Development Control
Ribble Valley Borough Council

Application no: 2023/0338

Address: Newlands Back Lane Chipping PR3 2QA

Proposal: Proposed sheep shed and widening of existing site access.

project	project number	drawing number
Newlands House	2306	PL.01
Proposed Site Plan, Floor plans and Elevations		
scale	date	status
1 to 100 @ A1	april 2023	planning
revision	revision	
A	A

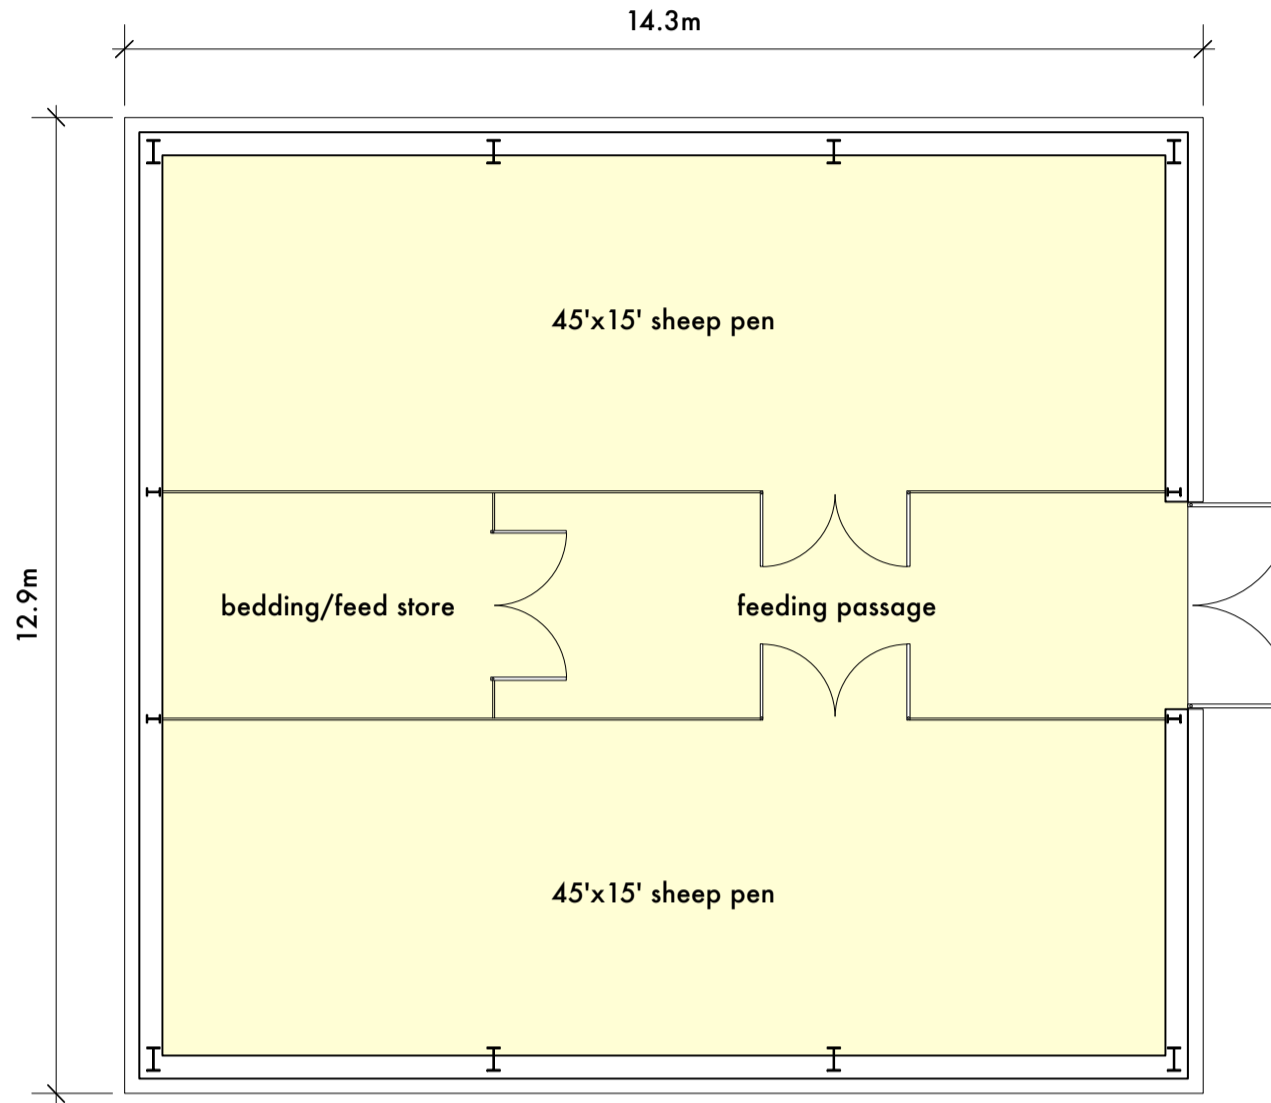
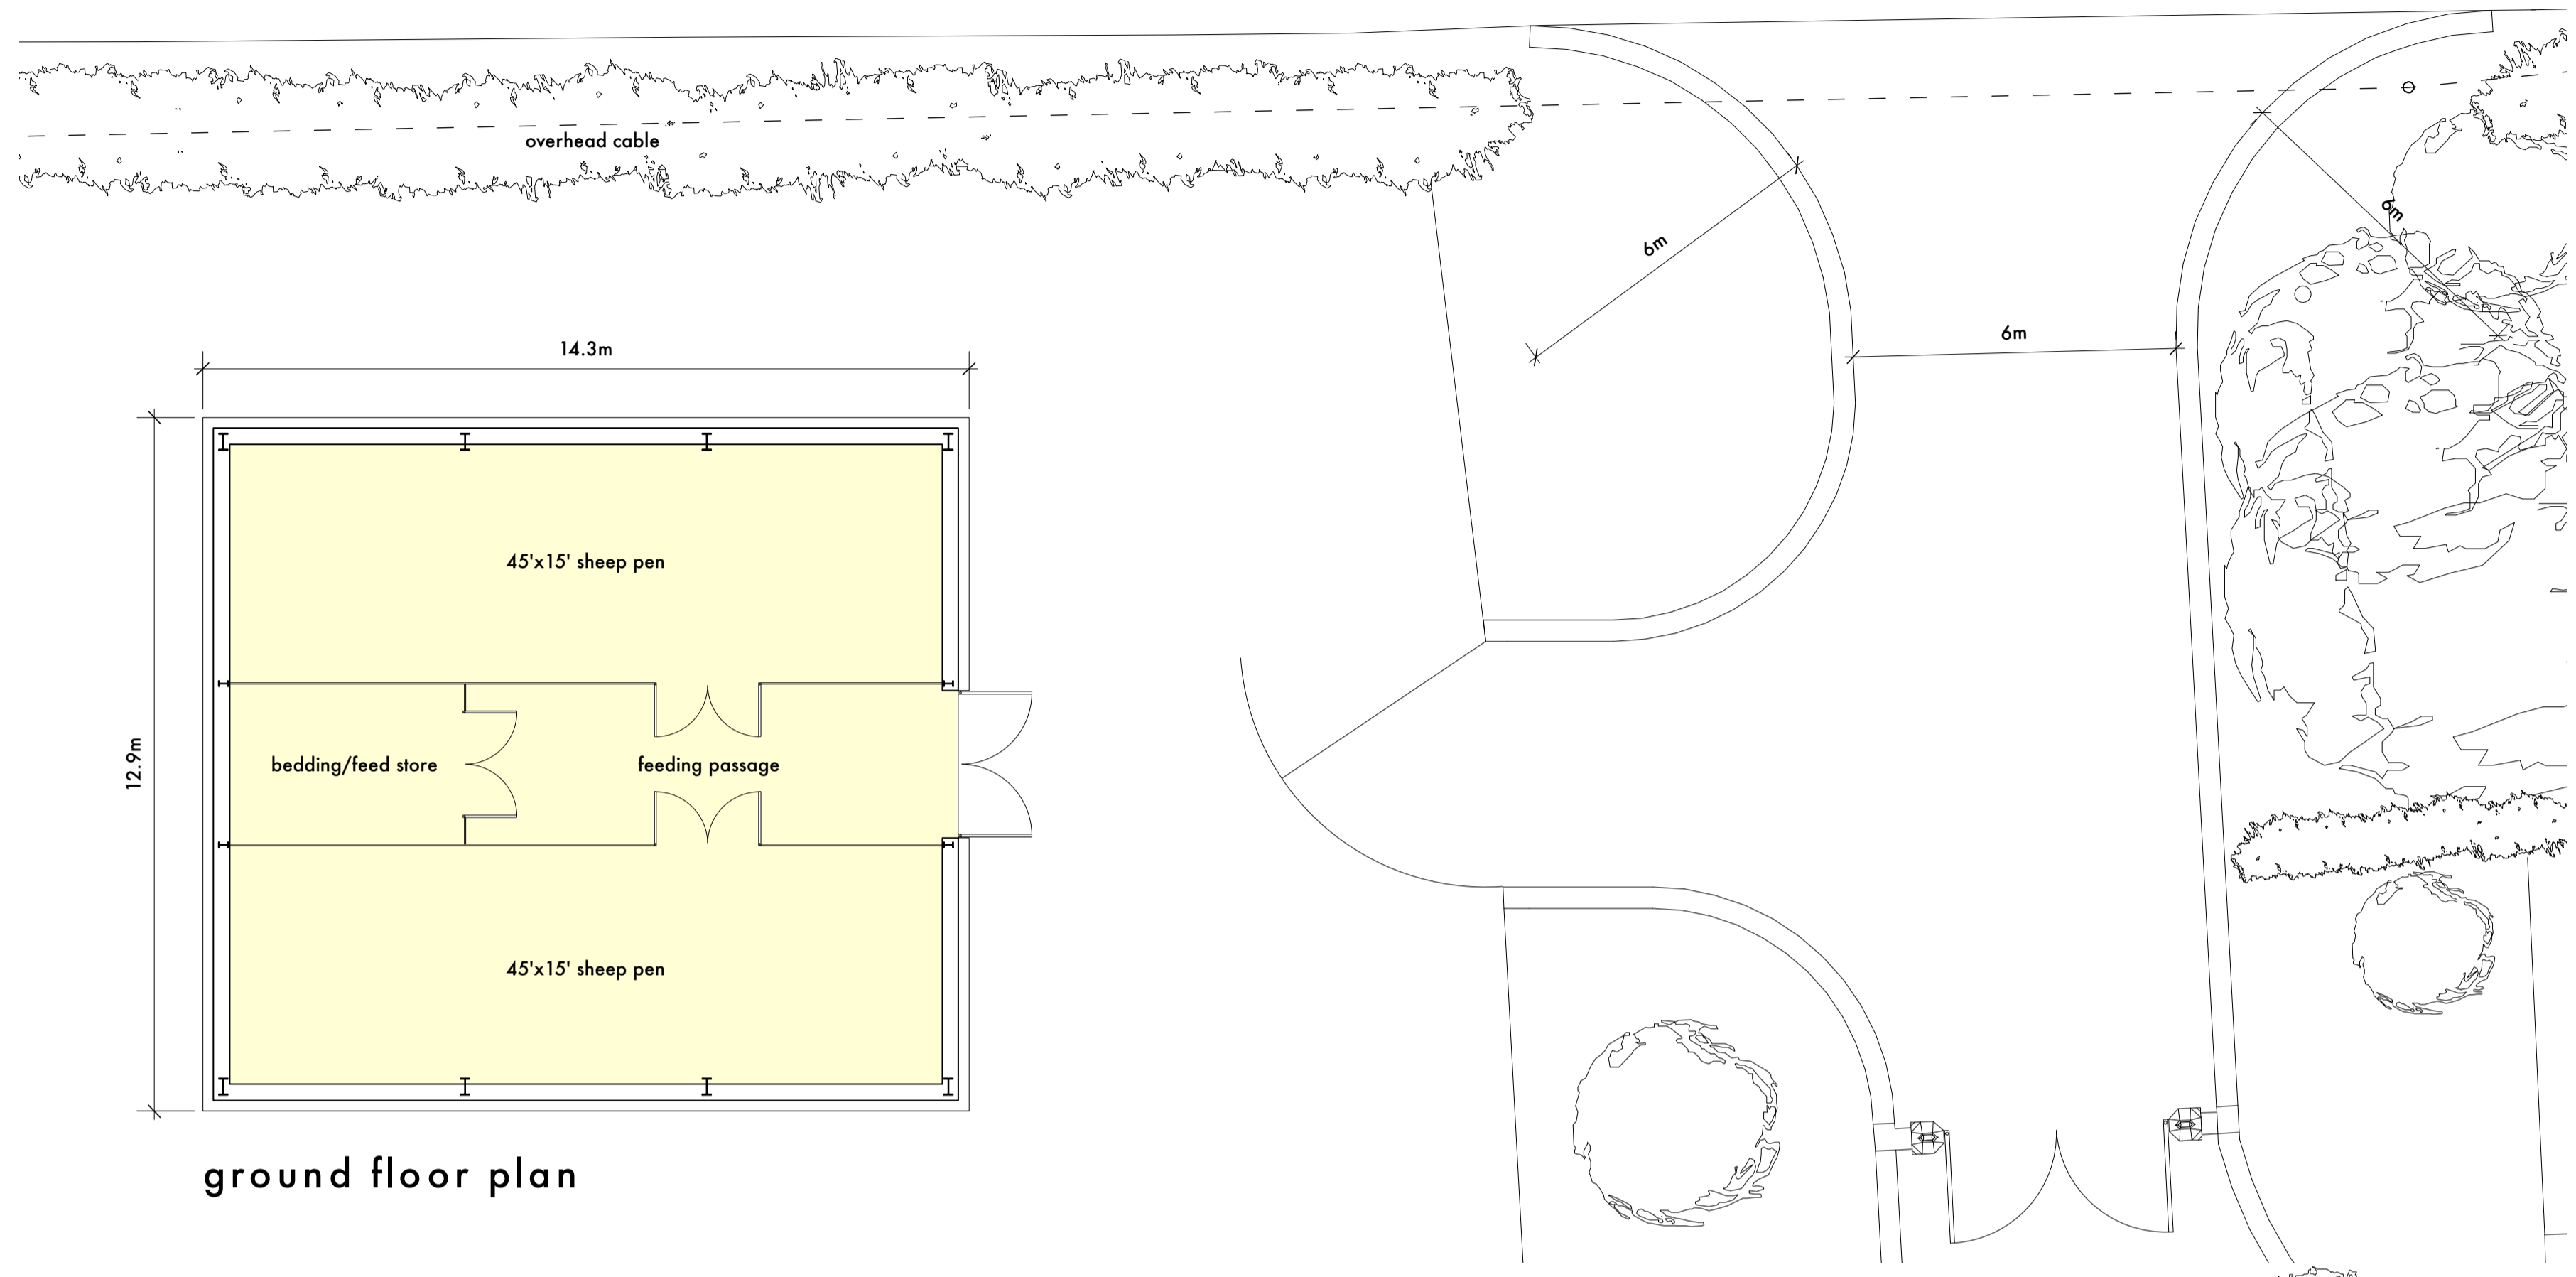
In order to fully support the application, we would look for further submissions showing the visibility splay available at the entrance. This should be measured at a point 2.4m back from the edge of the carriageway for a distance of at least 65m to the nearside edge of the carriageway in either direction. Any structure planting of other similar obstruction that falls within the visibility splay shall be reduced in height to 0.95m.

a) Visibility splays.

No building (or use hereby permitted) shall be occupied (or use commenced) until visibility splays 2.4 metres back from the centre line of the access and extending 65m metres on the nearside carriageway edge in both directions have been provided at all accesses/junctions, as shown on the approved plans. Nothing shall be erected, retained, planted and / or allowed to grow at or above a height of 0.9 metres above the nearside carriageway level which would obstruct the visibility splay. The visibility splays shall be maintained free of obstruction at all times thereafter for the lifetime of the development.
